ExQ2	Question to:	Question:
1.	General and cross-topic questions	
1.0	Consideration of application – general matters	
Q1.0.1	The applicants	<p>Change log for application documents</p> <p>Please can the applicants provide a change log for each application document at each deadline hereafter. The change log should comprise three columns. The first column should list the documents, with hyperlinked examination library reference numbers, that have been changed since the previous deadline. The second column should provide a summary that is proportionate but still of sufficient substance to fully understand what was changed and why it was changed. The third column should identify the catalyst for the change and use hyperlinked examination library reference numbers accordingly.</p> <p>For example, if the LEMP was changed to include new requirements in relation to ecology surveys in response to interested party comments, the first column would list the LEMP, the second column would summarise the new requirements and why they were necessary in light of the interested party comments, and the third column would identify the document within which the interested party comments were made.</p> <p

Drawing file: published-documents / BC0410001-001269-DCO 2.16 Community Park Plan Deadline 4.pdf

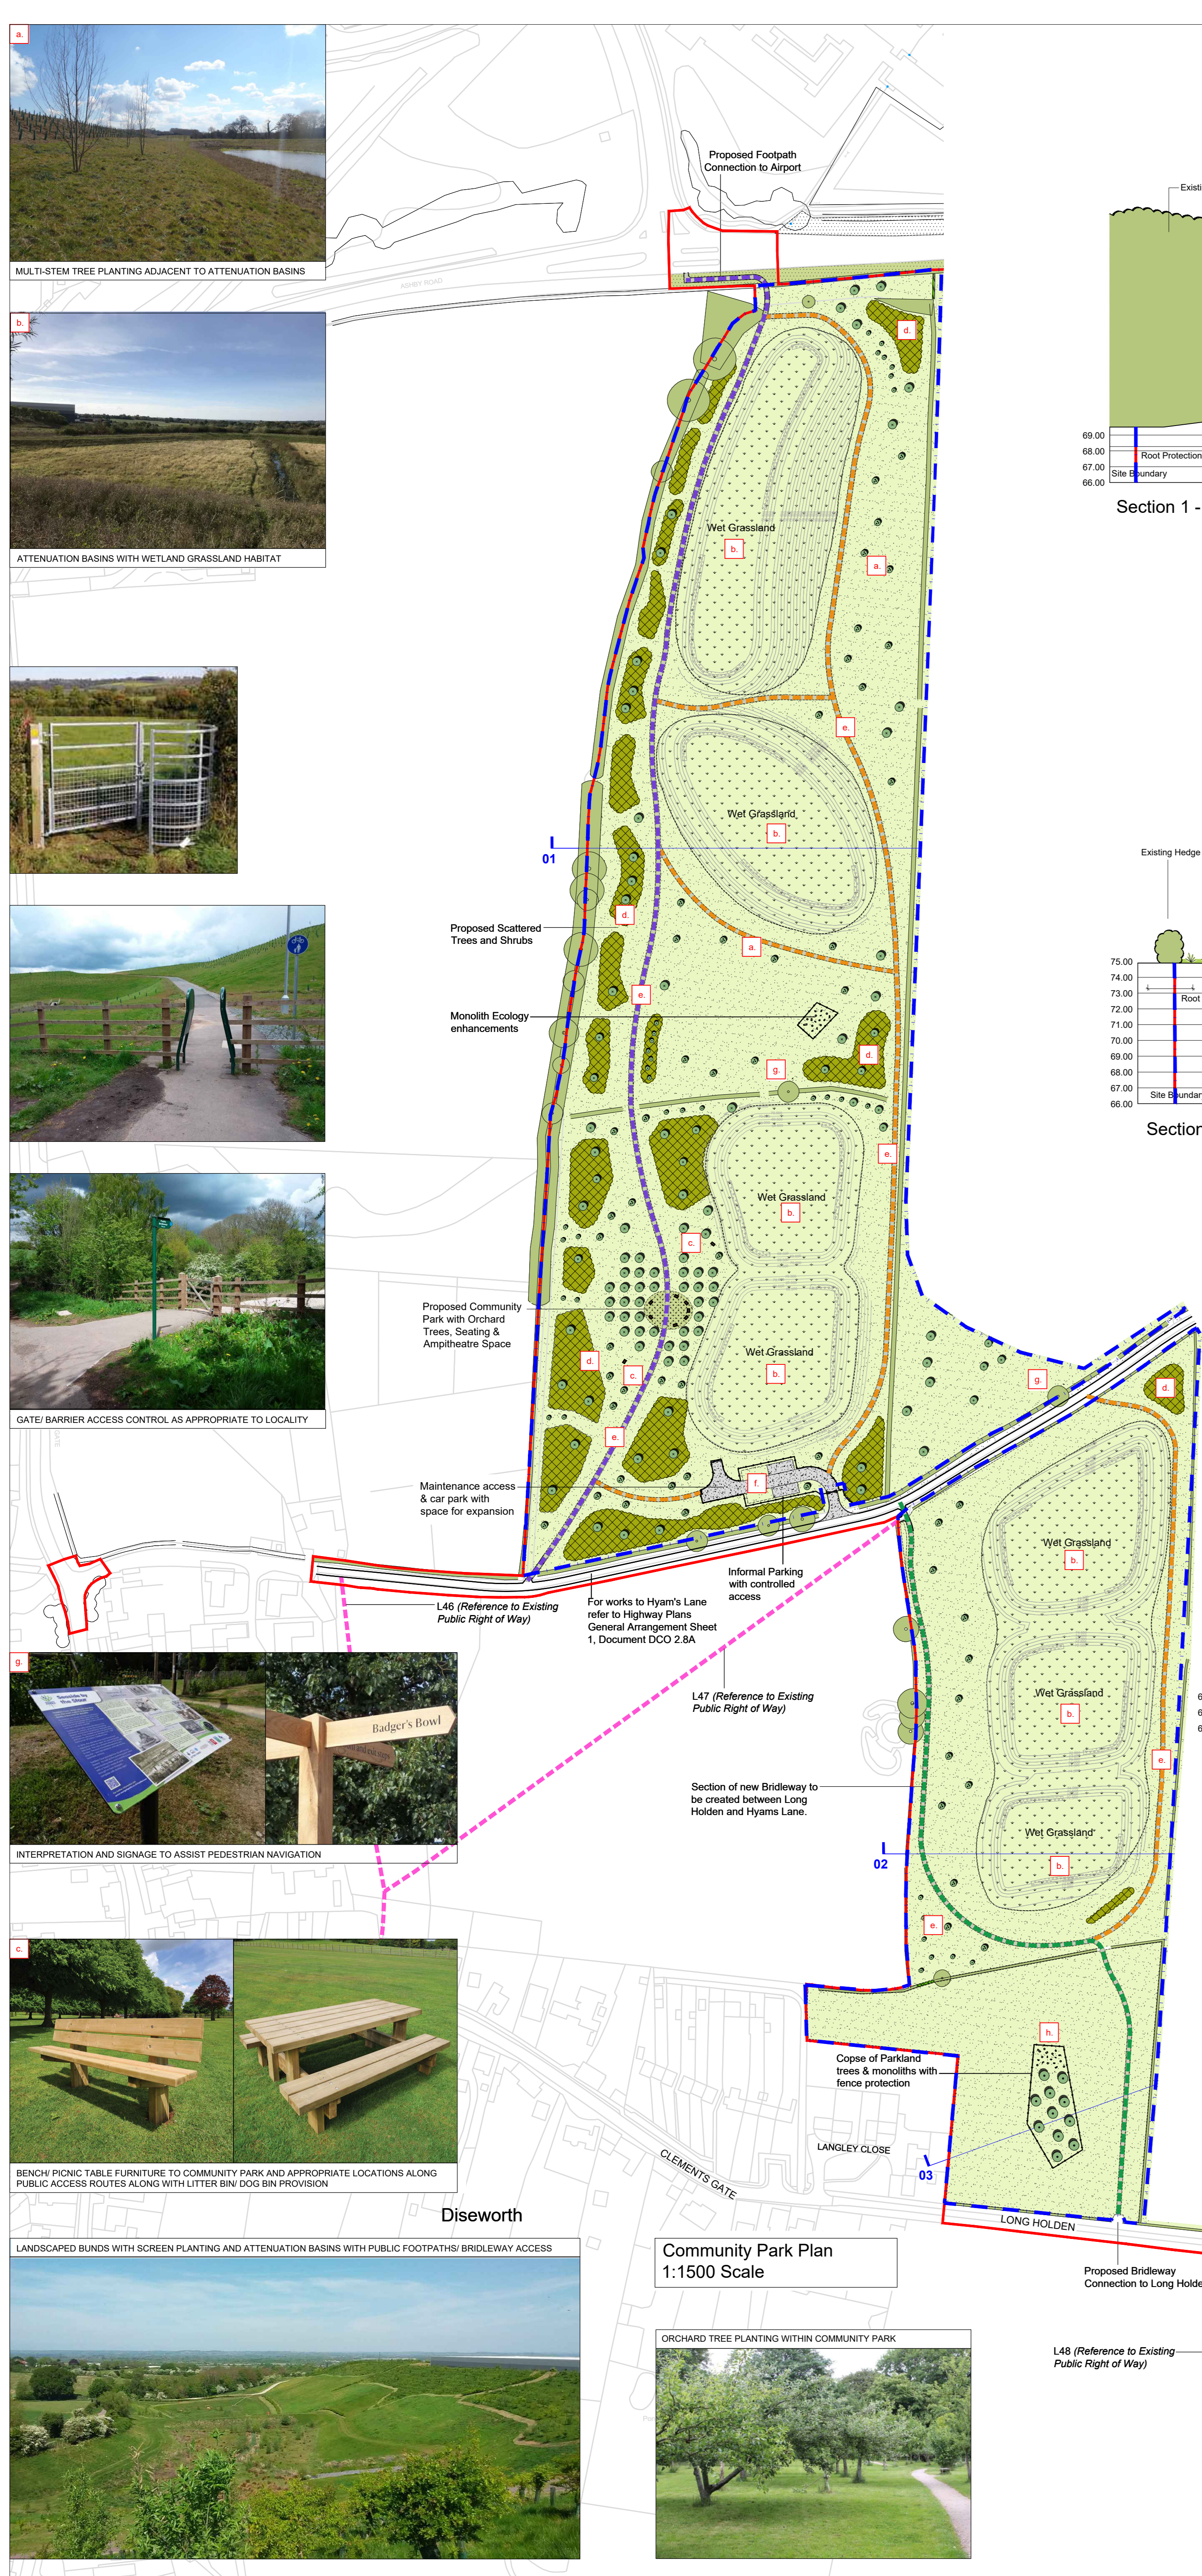
Q1.2.2	The applicants	<p>Community Park Plan</p> <p>The issue of competing usage across the community park has been raised in relation to several issues. In this context, please can the applicants provide a community park plan that shows all the relevant components and the associated space requirements of each, including any buffer zones or design standards required by policy or guidance. The role of the plan is to demonstrate to the ExP whether all the proposed components therein can be accommodated without any unacceptable spatial conflicts or tensions.</p>
